Sizewell C (SZC)

Planning Inspectorate Reference: *EN010012*

Deadline 8 – 24 September 2021

East Suffolk Council comments on Deadline 7 submissions from the Applicant

DRAWING NO:
SZC-SZ0100-XX-000-DRW-100200

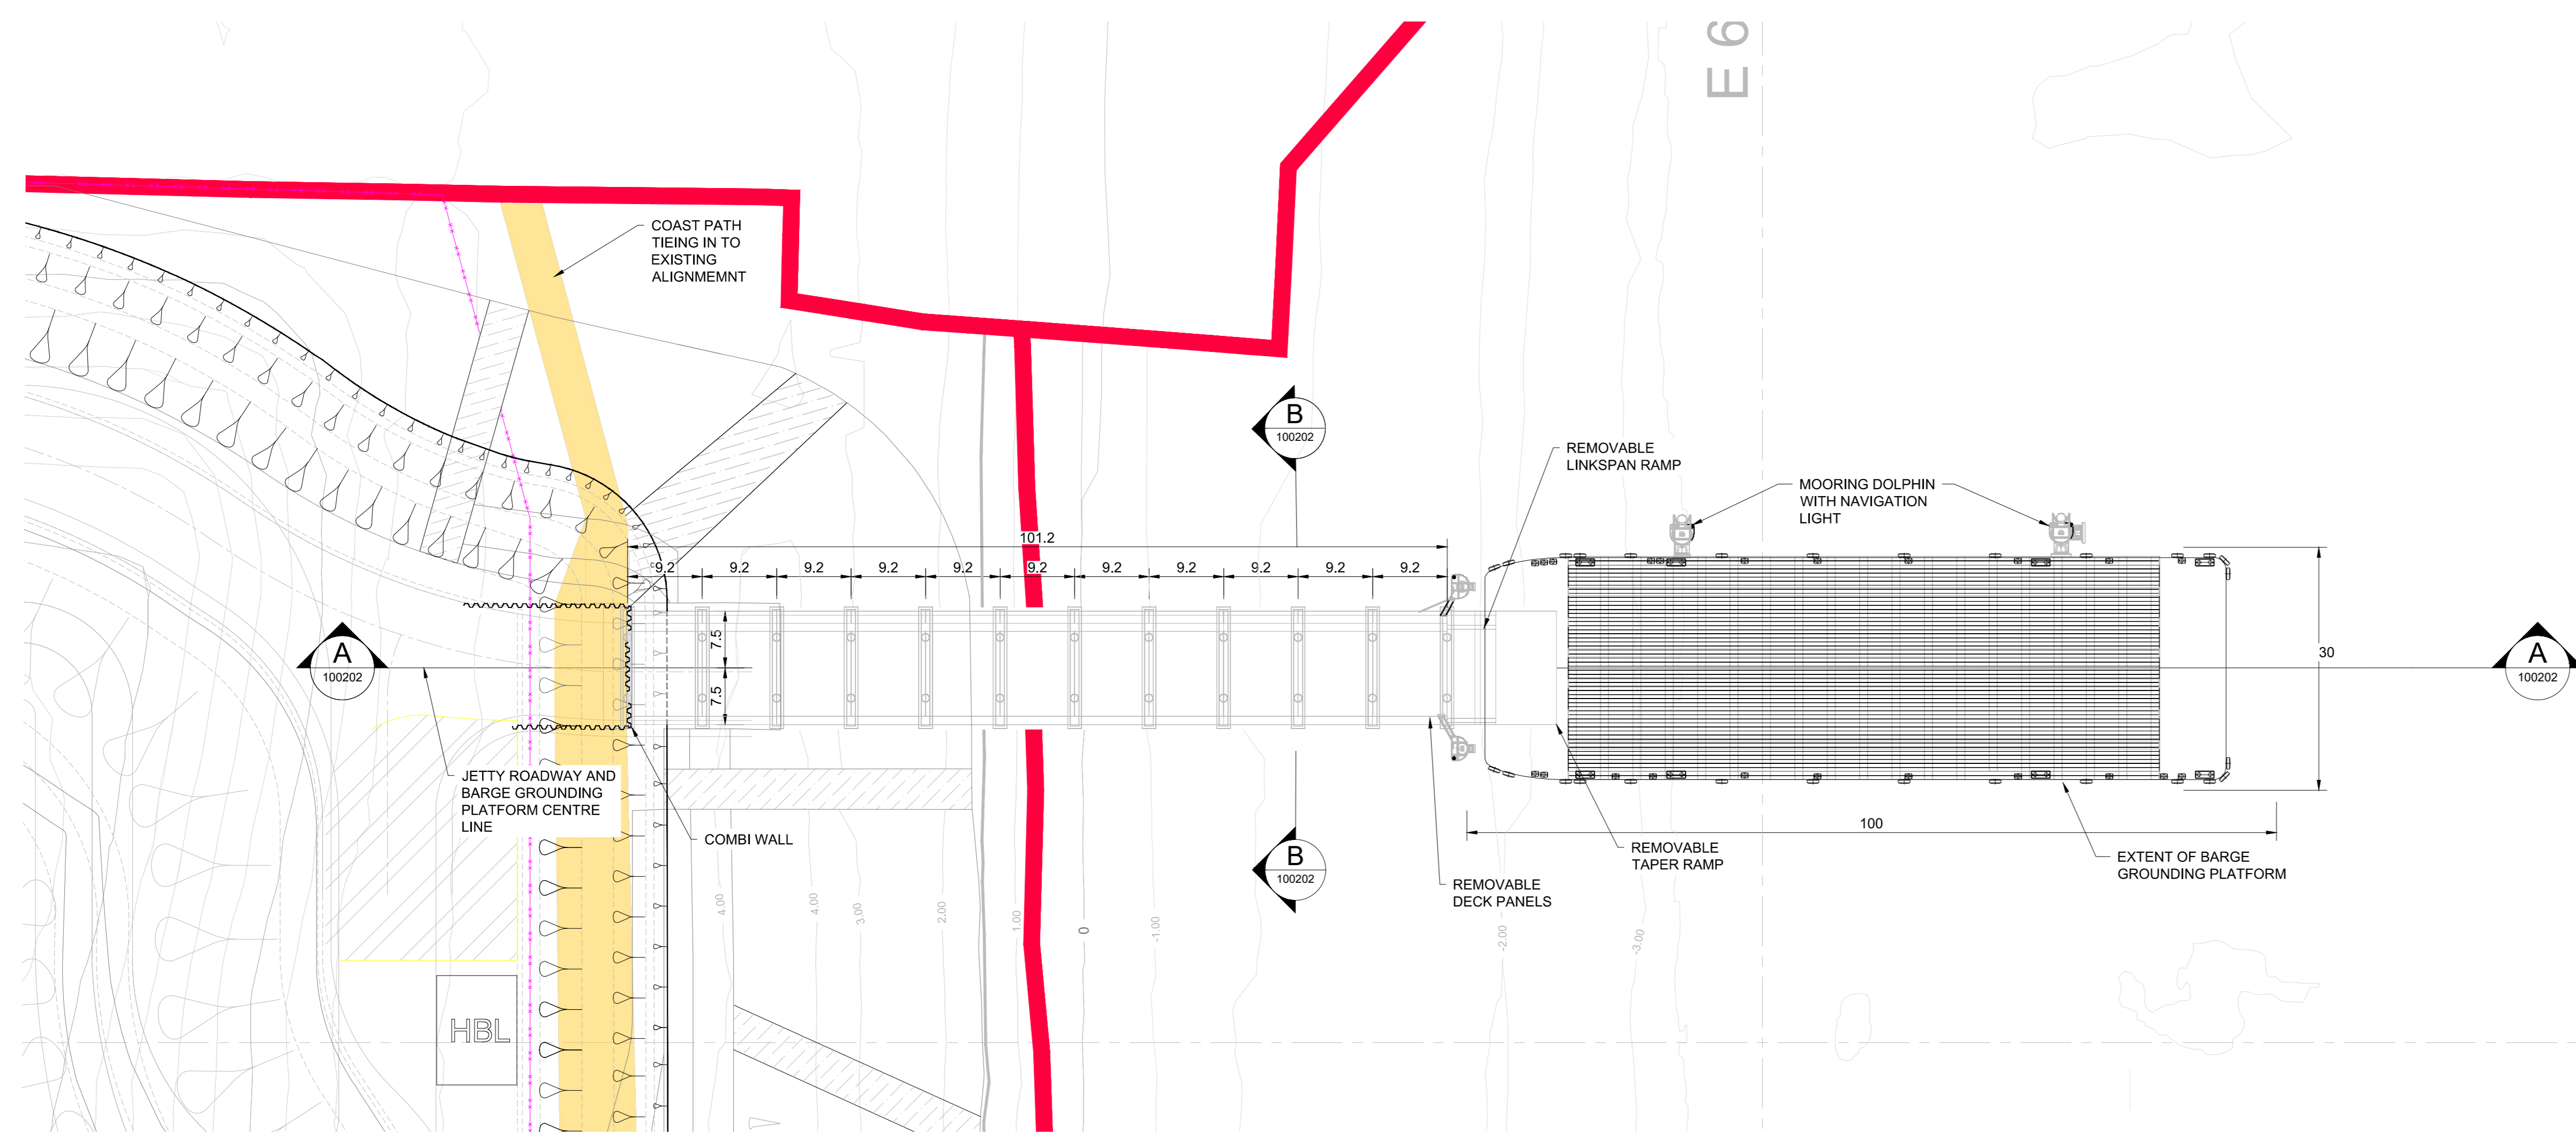
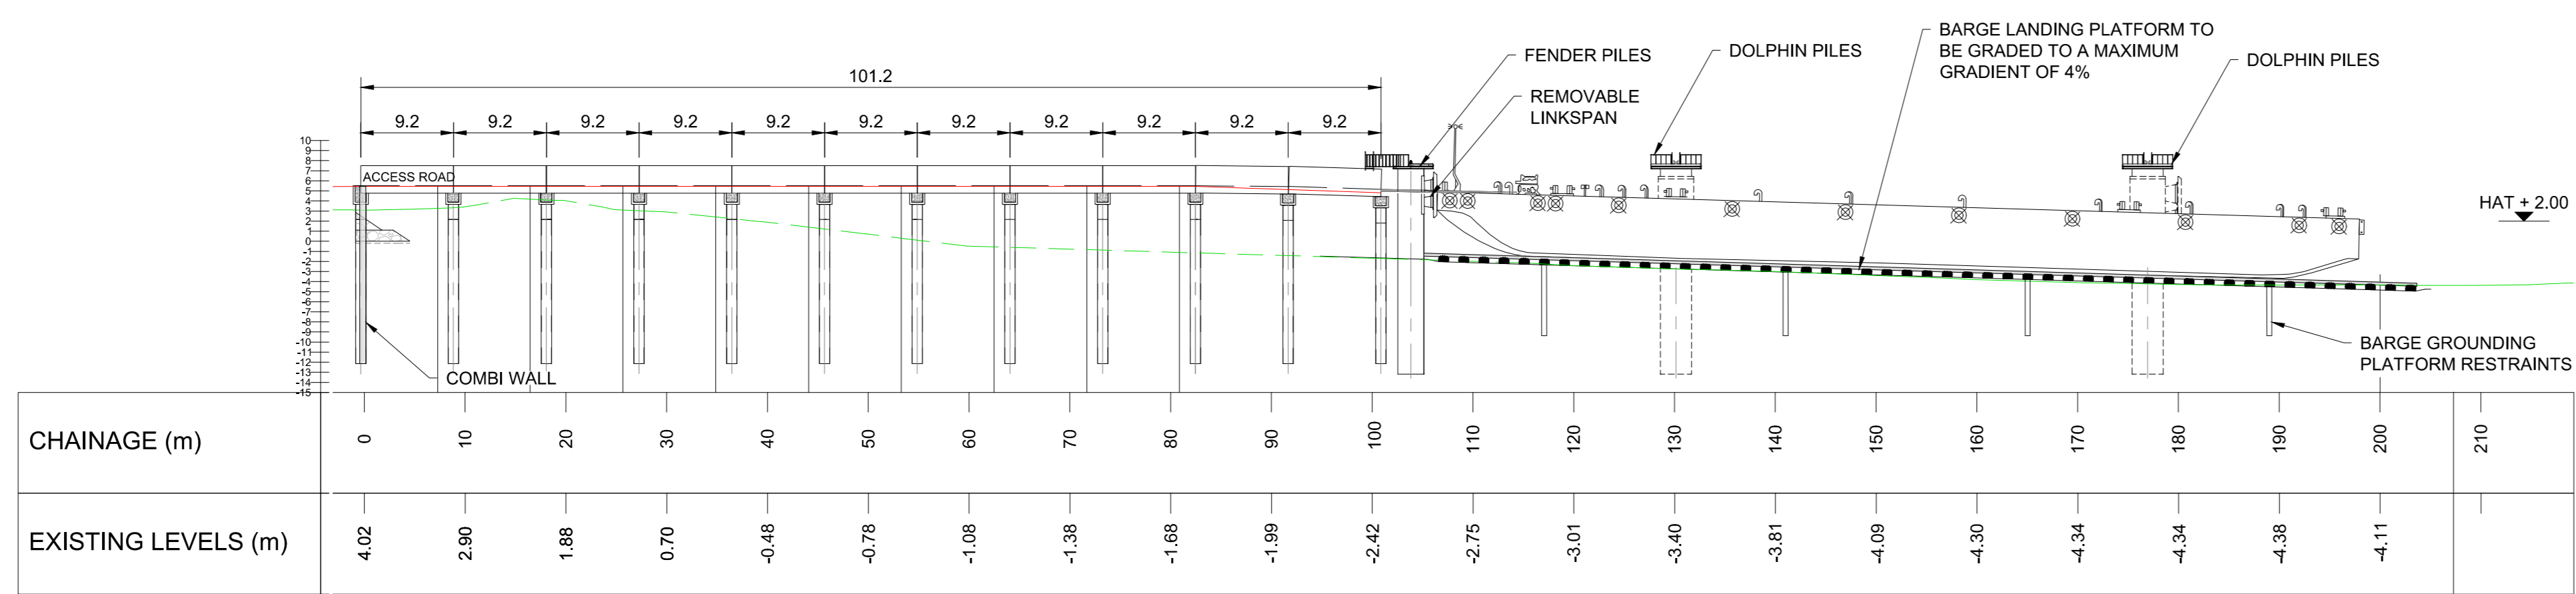
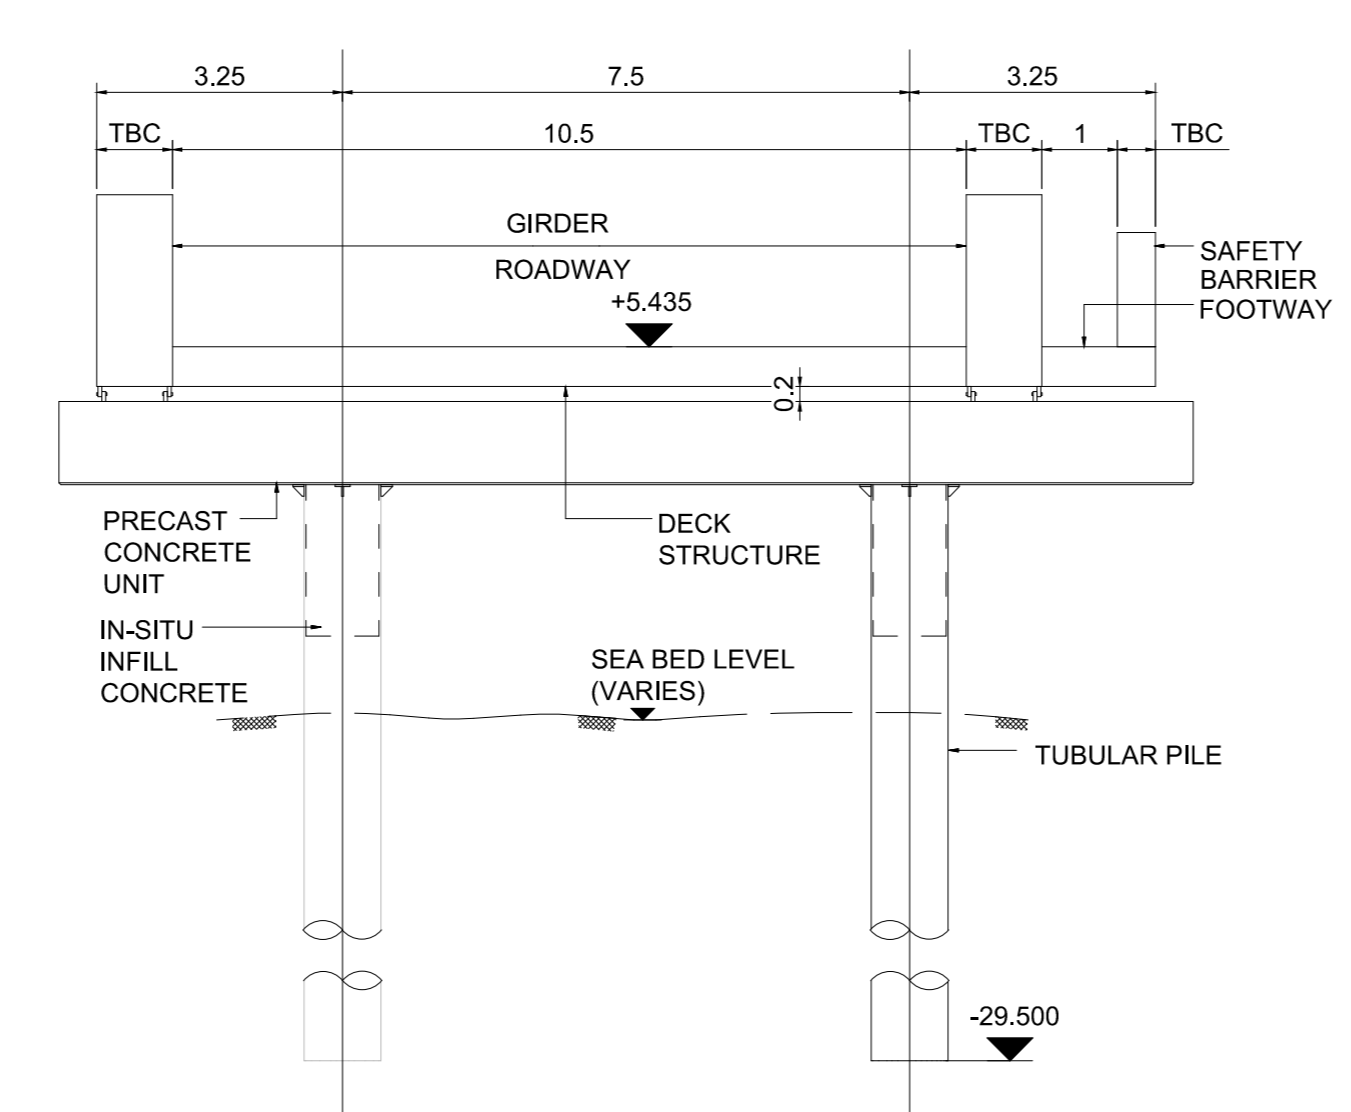
Pg. No.	Section Ref.	Relevant Text / Illustration	Observations and Concerns	Requested
4	DRW-100202 Perm BLF	<i>Green line – assumed indicative existing beach profile.</i>	Is the existing beach profile accurate for this chainage?	Confirmation.
4		<i>Barge grounding platform and restraints</i>	Is the platform a concrete mattress?	Confirmation.
4		<i>Tracks / Pathways across Hard and Soft Coastal Defence.</i>	Are these permanent engineered structures that could compromise the erodibility of the SCDF or otherwise act as a block to sediment movement to seaward of the HCDF?	Confirmation there are no hard structures within the SCDF envelope.
4			How will the BLF affect or be affected by construction of an Adaptive HCDF	Explanation.
5	DRW-100203 Temp BLF	<i>Piles within Hard and Soft Coastal Defence.</i>	Will the piles interfere with the Hard and Soft Coastal Defence design and construction?	Explanation of whether the piles will be extracted or cut? Explanation of the level to which the temporary BLF piles be removed?
